From: Michael Eastham
Sent: 11 January 2018 08:19
To: Planning.Responses
Subject: LU/278/17/RES - Lyminster Bypass - response to EHO comments

From: 
Sent: 10 January 2018 18:31
To: Michael Eastham
Subject: Lyminster Bypass - response to EHO comments

Landscape Proposals SLB1
1 of 2

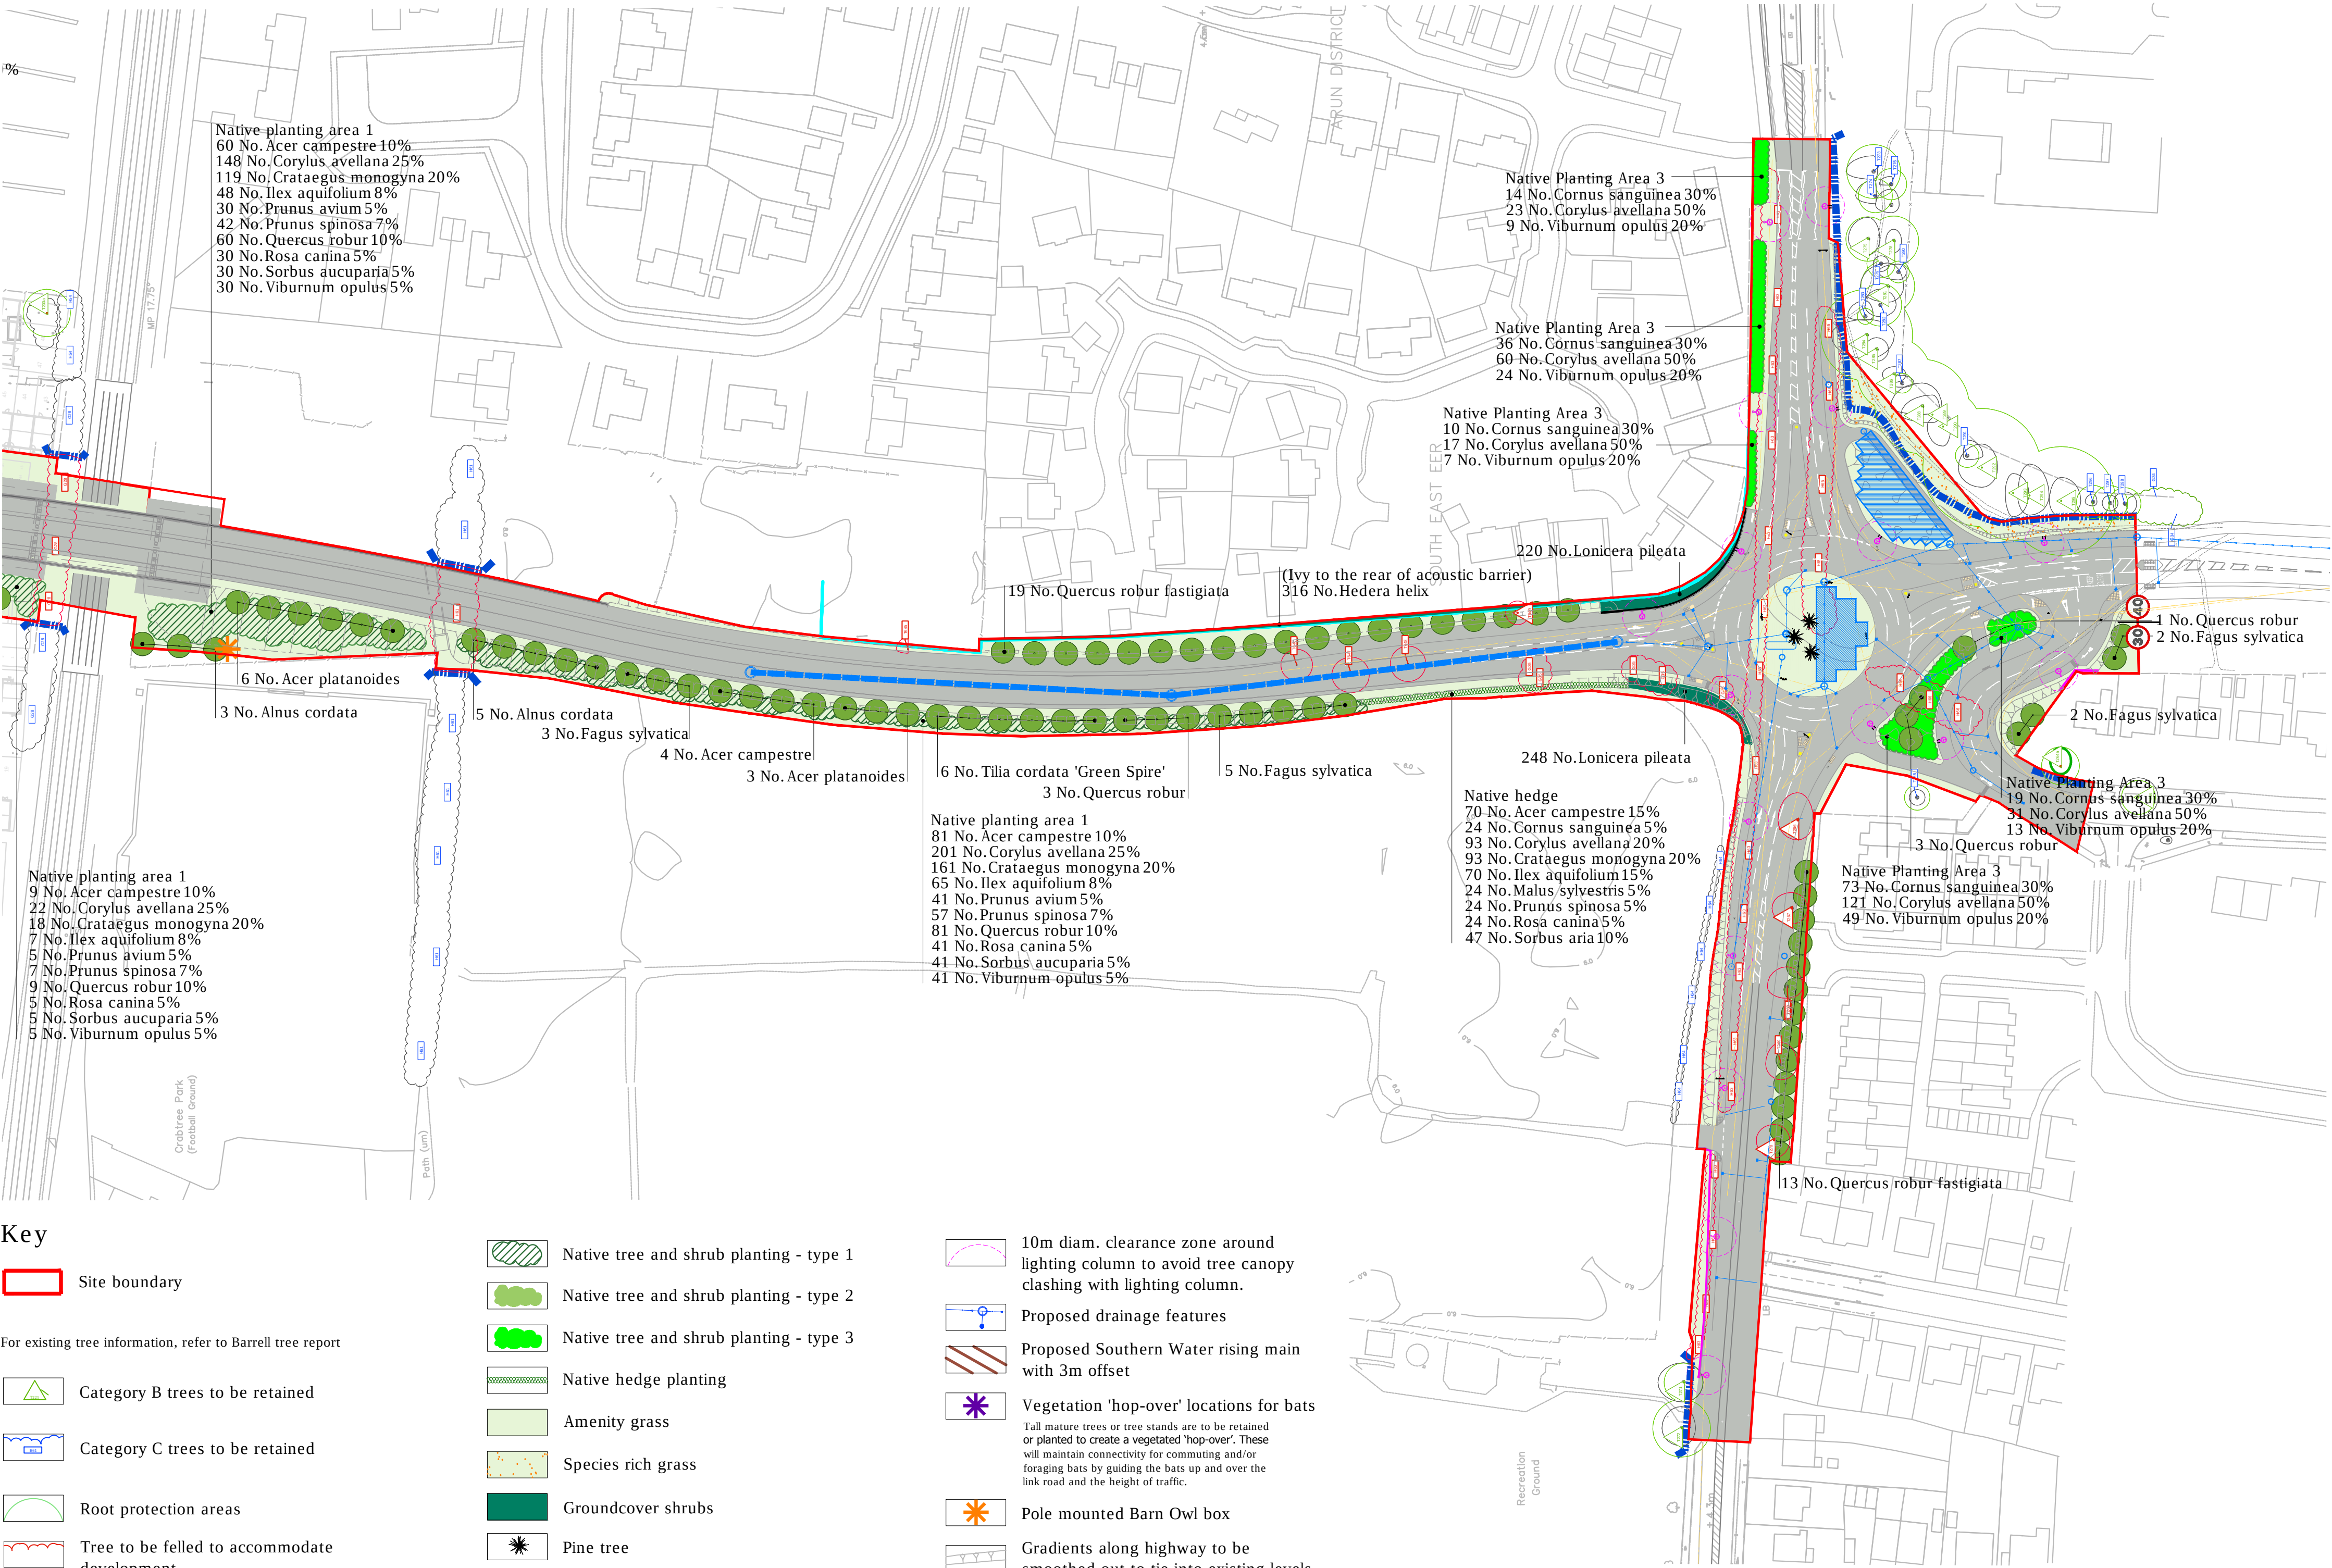
I can also confirm that the height of the barrier is 3.0m. The 3.5m cited on the planning statement is my error.
